**From:** Contact Centre (CRM) <contact@ribblevalley.gov.uk>  
**Sent:** 15 December 2024 17:57  
**To:** Planning  
**Subject:** Planning Application Comments - Application 3/2021/0275 FS-Case-670710728

**Planning Application Reference No.:** Application 3/2021/0275

**Address of Development:** Land behind the Dog Inn Longridge

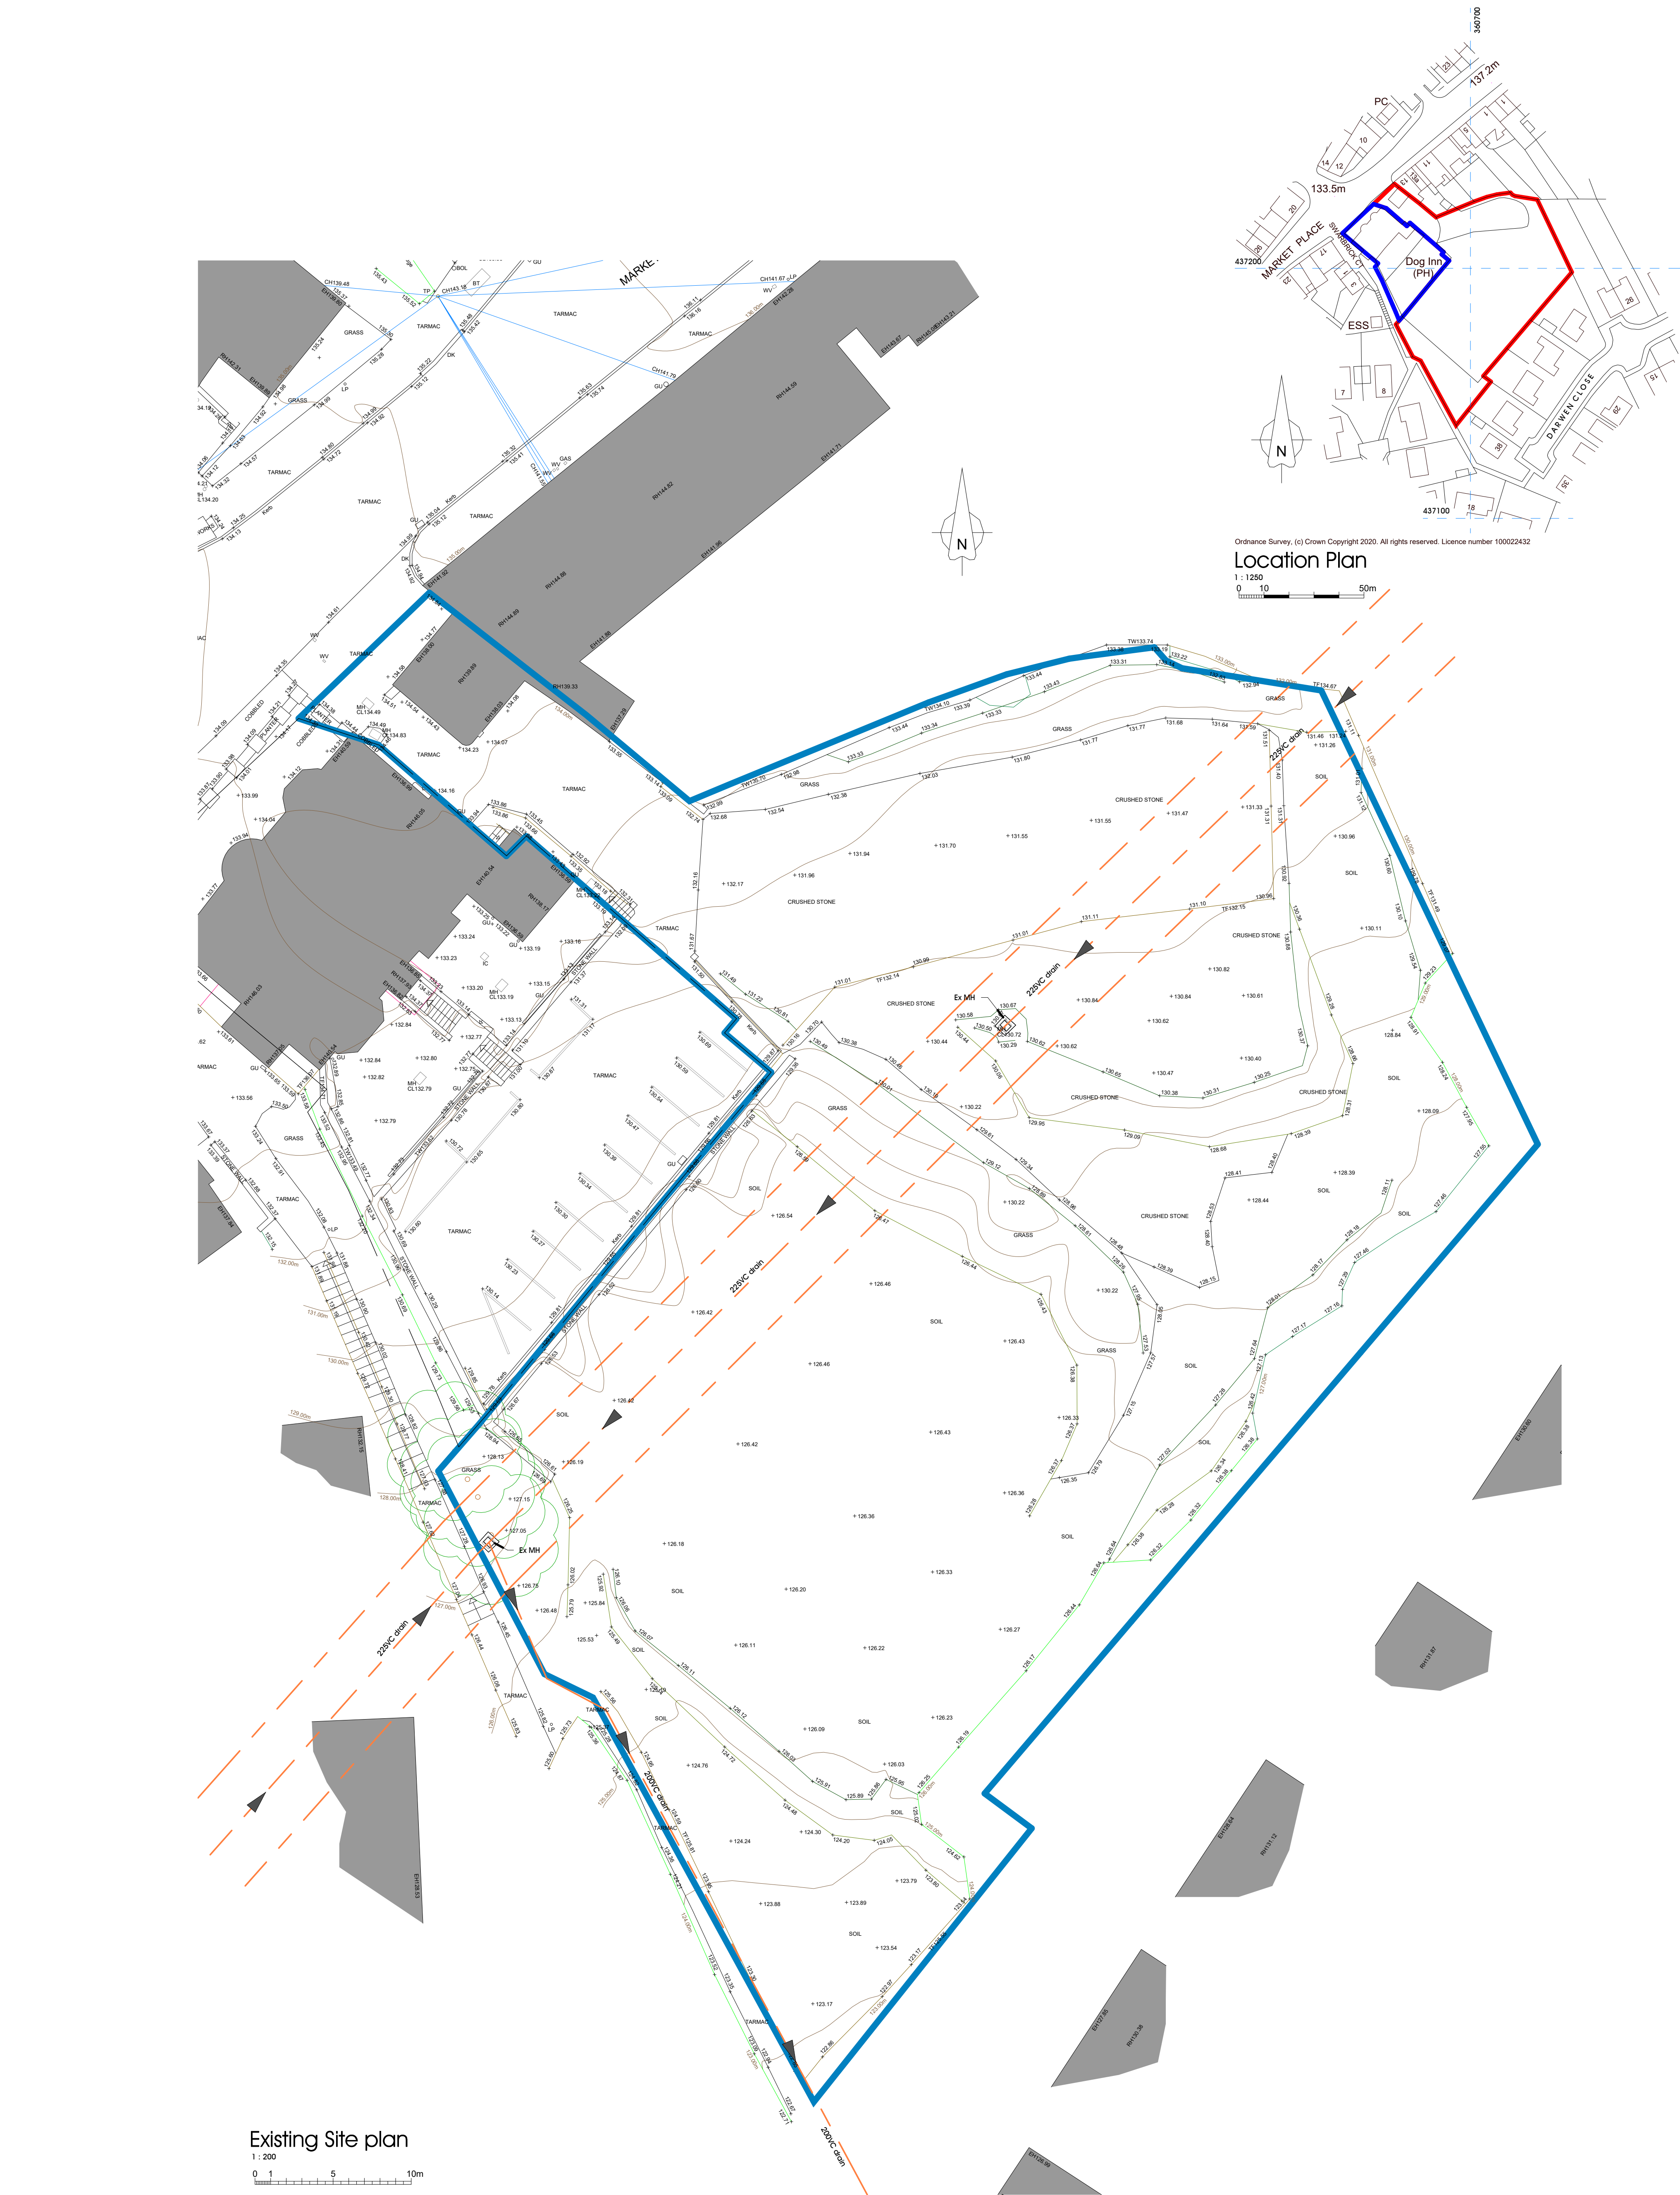
**Comments:** We object to the above planning application for the following reasons. Revised plans show additional 2 x buildings along the eastern border these are at a higher elevation than any previously proposed properties and would increase significantly water run off, noise and oversight to our homes. Some gardens already suffer from additional water run off from the ground works already taken place without planning permission. All properties continue to be at a much higher elevation to the existing homes on Darwen Close and will cause an invasion of privacy.
